Your reference: SSD 5348
 Our reference: ECM 4396078
 Contact: Robert Craig
 Telephone: (02) 4732 7593

4 November 2013

State Significant Development Application for Stage 3A Subdivision of North Penrith Defence Site (SSD-5348)

Proposed Water Cycle Management Plan

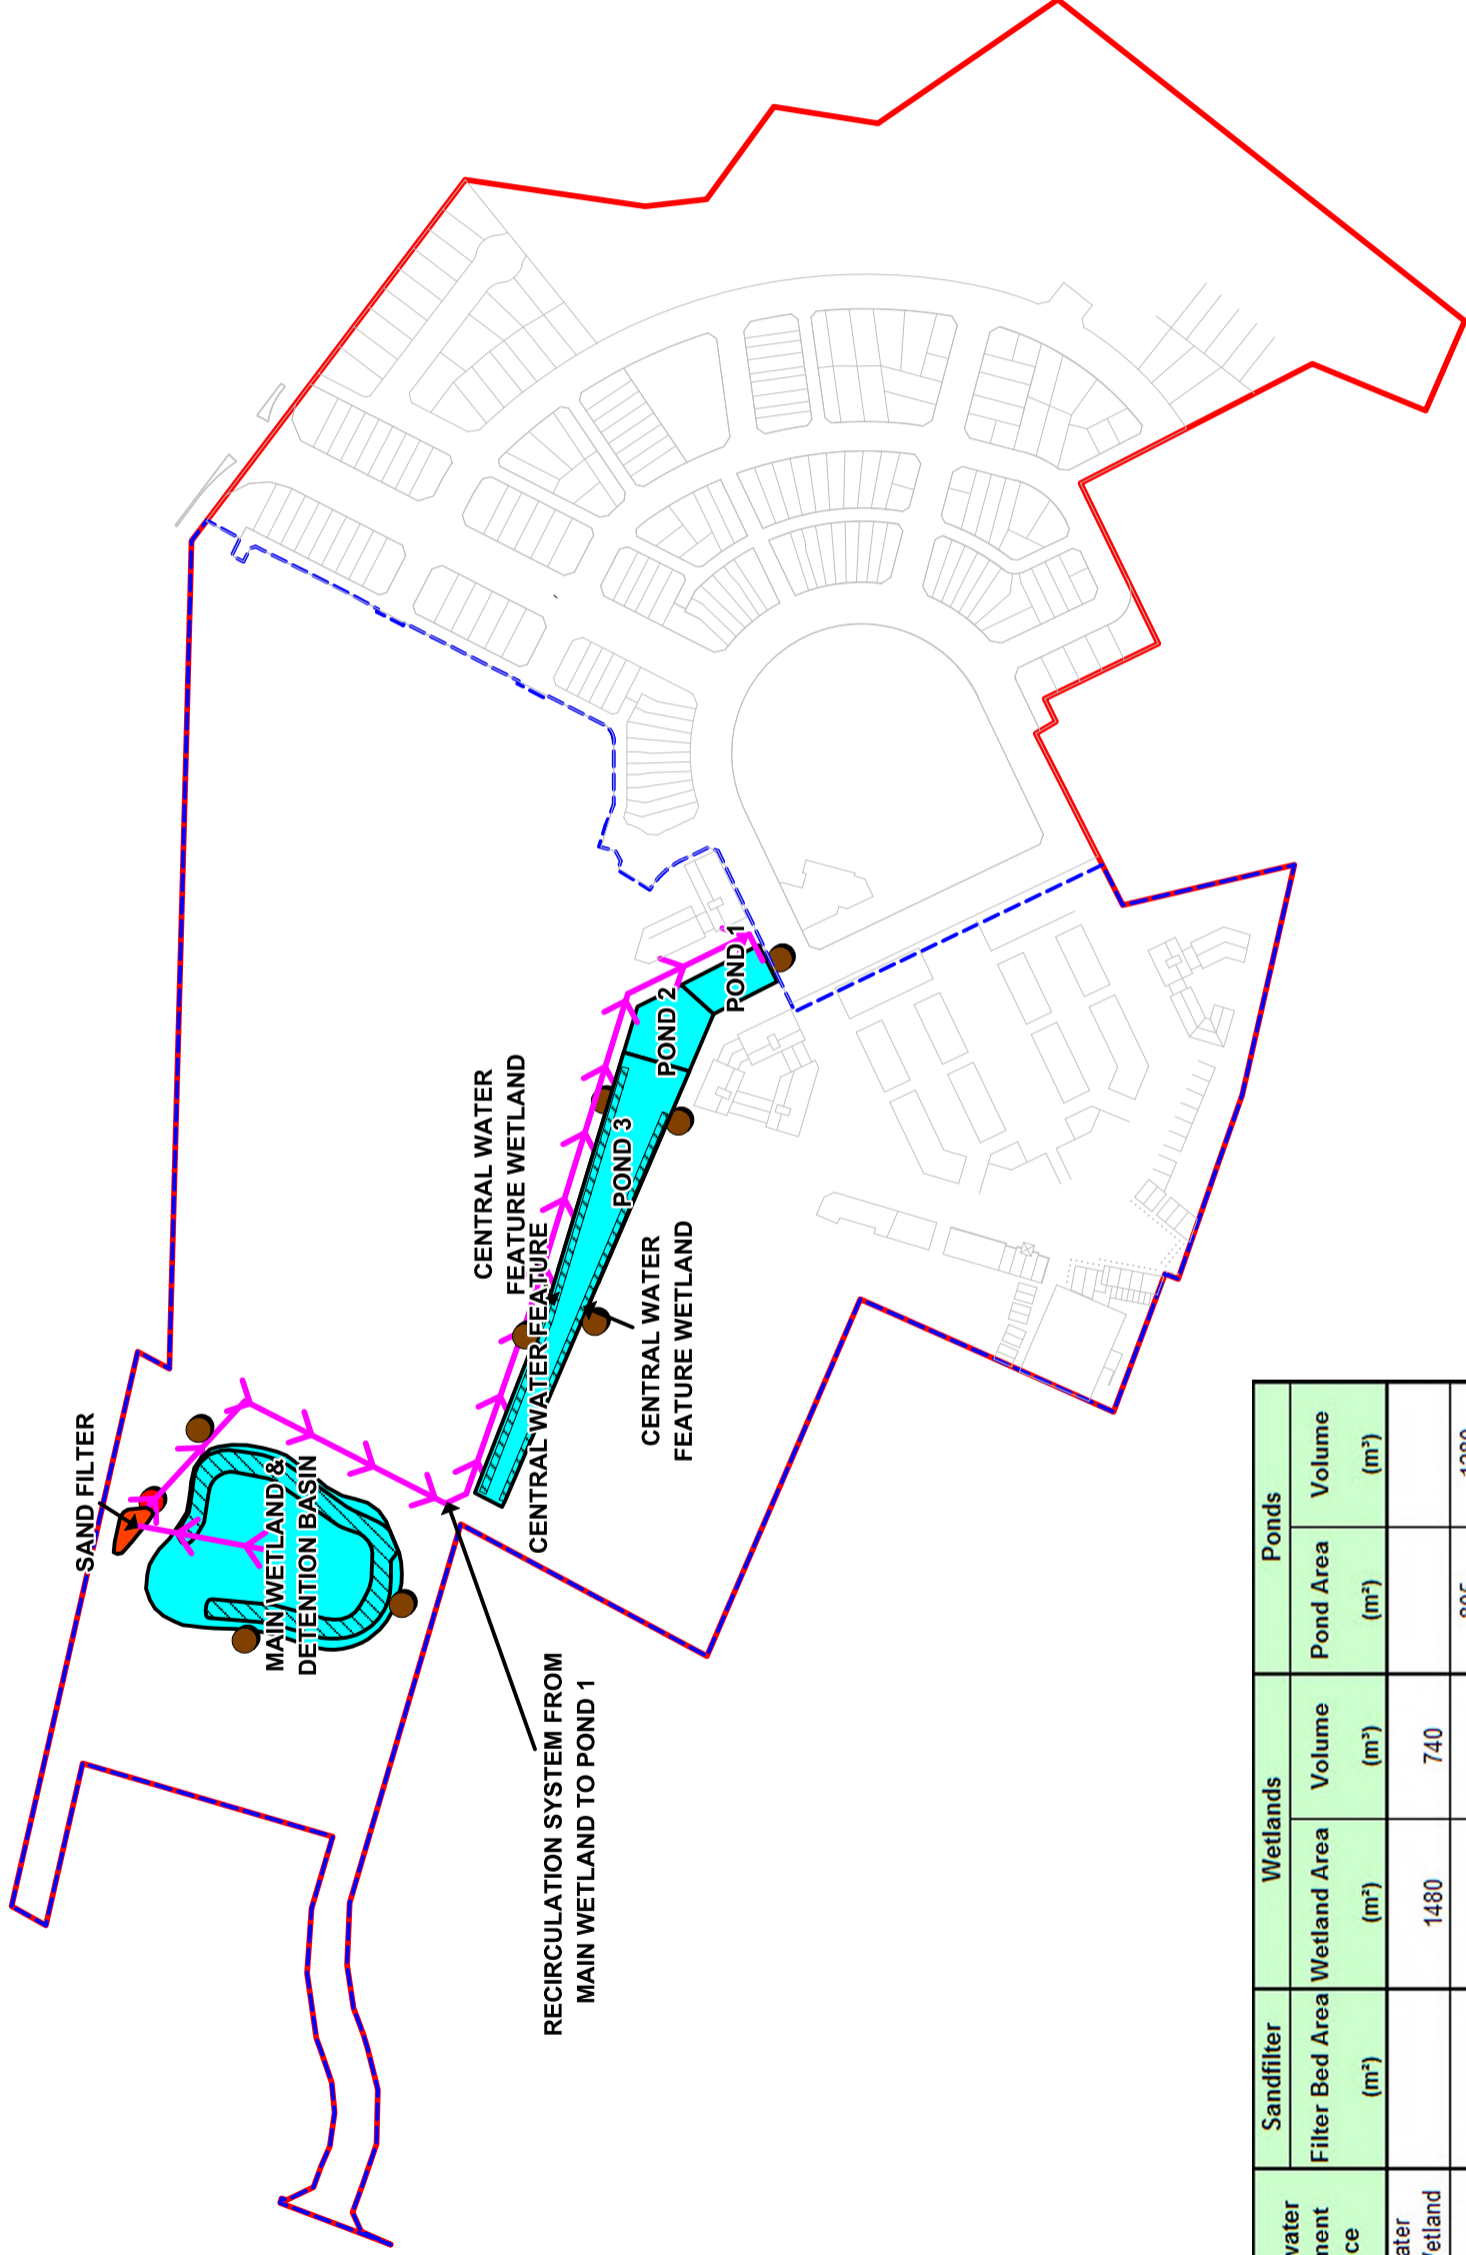
- The development shall be undertaken in accordance with the proposed management actions outlined in the 'North Penrith Stages 2B-3B Water Cycle Management Strategy Report Incorporating Water Sensitive Urban Design Techniques' dated 17 October 2012 and prepared by J. Wyndham Prince.
